2nd July 2014
Your Ref: HP13077

Former Bodyshop office, Courtwick Lane, Littlehampton

Thank you for your response sent to my colleague Peter Herbert on the 16th June 2014 regarding the proposed GP practice at the above site.

client	Community Solutions	Coastal West Sussex CCG
project	New GP Surgery, Uththampton	East Wing 'Enterprise Hub'
file	Site Plan - proposed	
date	Feb 2014	1:200
scale	paper	drawn
checked	A1	SVR
33157	06	F

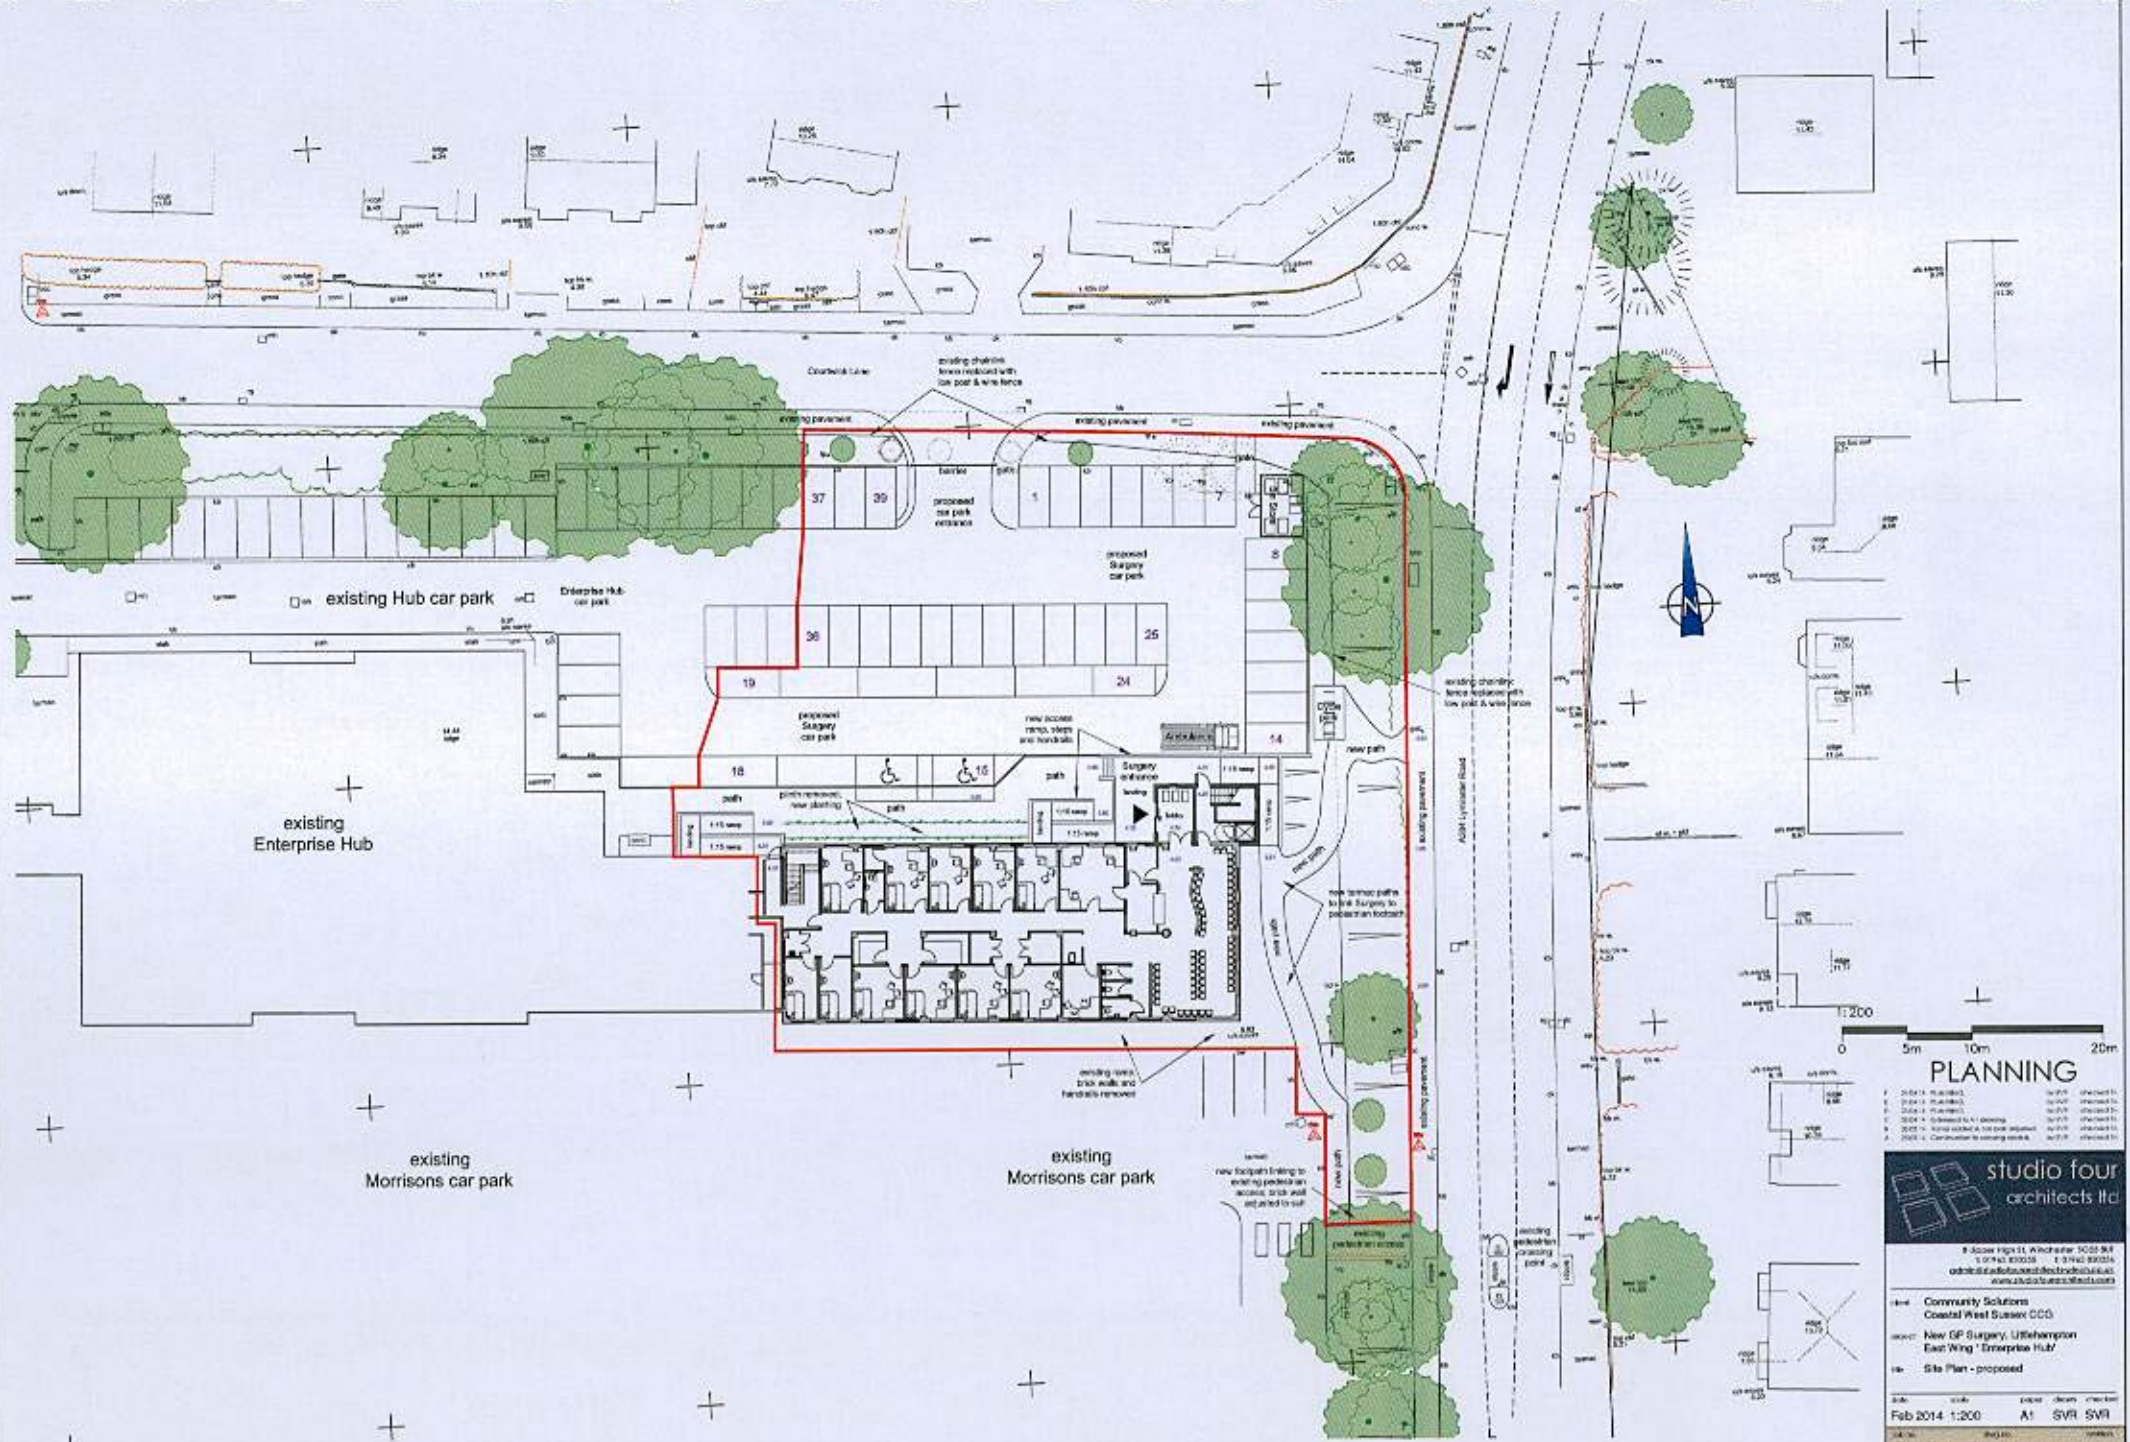
1. The inclusion of a second entrance from Courtwick Lane remains unacceptable and contradicts the original negotiations for the site. Local residents had raised many concerns regarding access points and had lobbied hard to achieve the single entrance option.

2. The location of bus stops for new bus service must be given consideration at this stage of the planning process. I would suggest that West Sussex County Council is contacted to discuss this matter further.
3. The limited proportion of car park spaces allocated to the Enterprise Hub is unacceptable and the introduction of additional spaces within the Morrison's site is inappropriate – remote car parking cannot be an attractive option for any potential new business.
